### **RE: Atlas Administrative Conditional Use Application (ACU-23-00003)**

Kittitas County Community Development Services received an Administrative Conditional Use Permit application on July 13, 2023, for a telecommunications facility on parcel 818833. The application packet as submitted has been deemed **incomplete** by CDS.

SITE PLAN

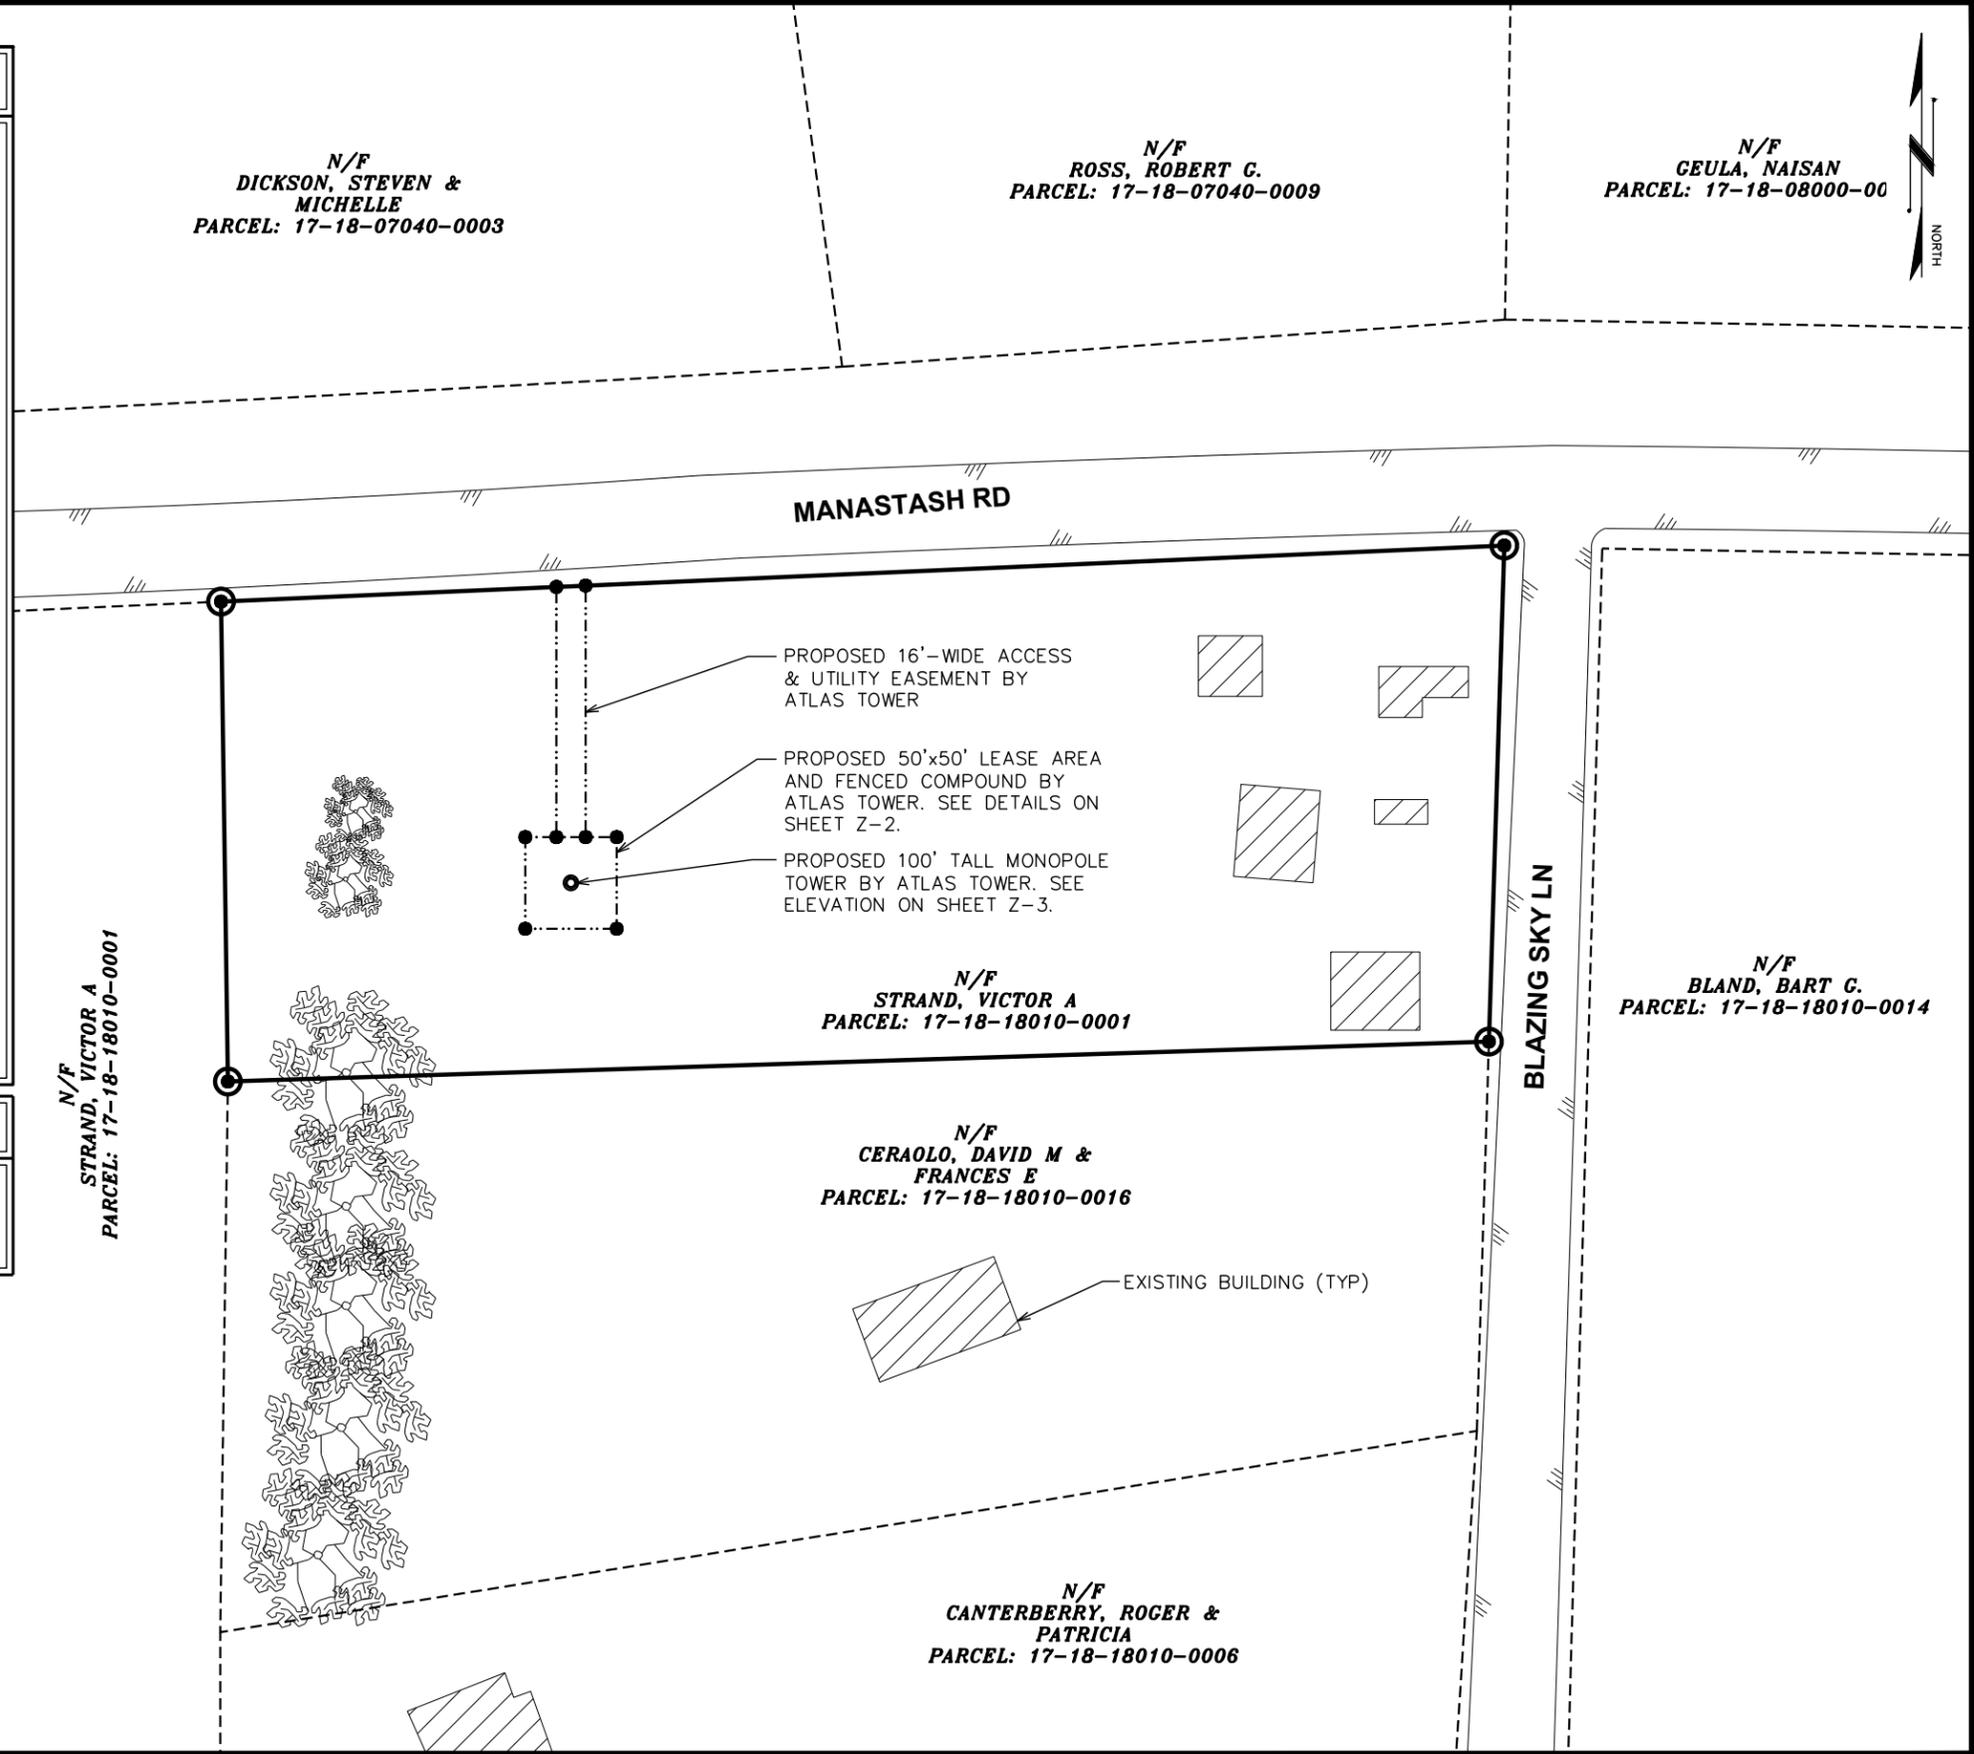
The site plan included in the application materials appears to show the monopole tower setback from the south property line at a distance of approximately 100 feet. Therefore, the application does not meet the requirements of KCC 17.61.040(3).

- a. An updated site plan displaying appropriate setbacks (1.2 time the height of the structure) for the tower.

- b. An explanation showing that to improve the facilities' reception and/or transmission capabilities or to achieve greater levels of audible or visual screening, the current setbacks are necessary. Additionally, please provide evidence that it would not be possible for the tower to fall on neighboring properties.
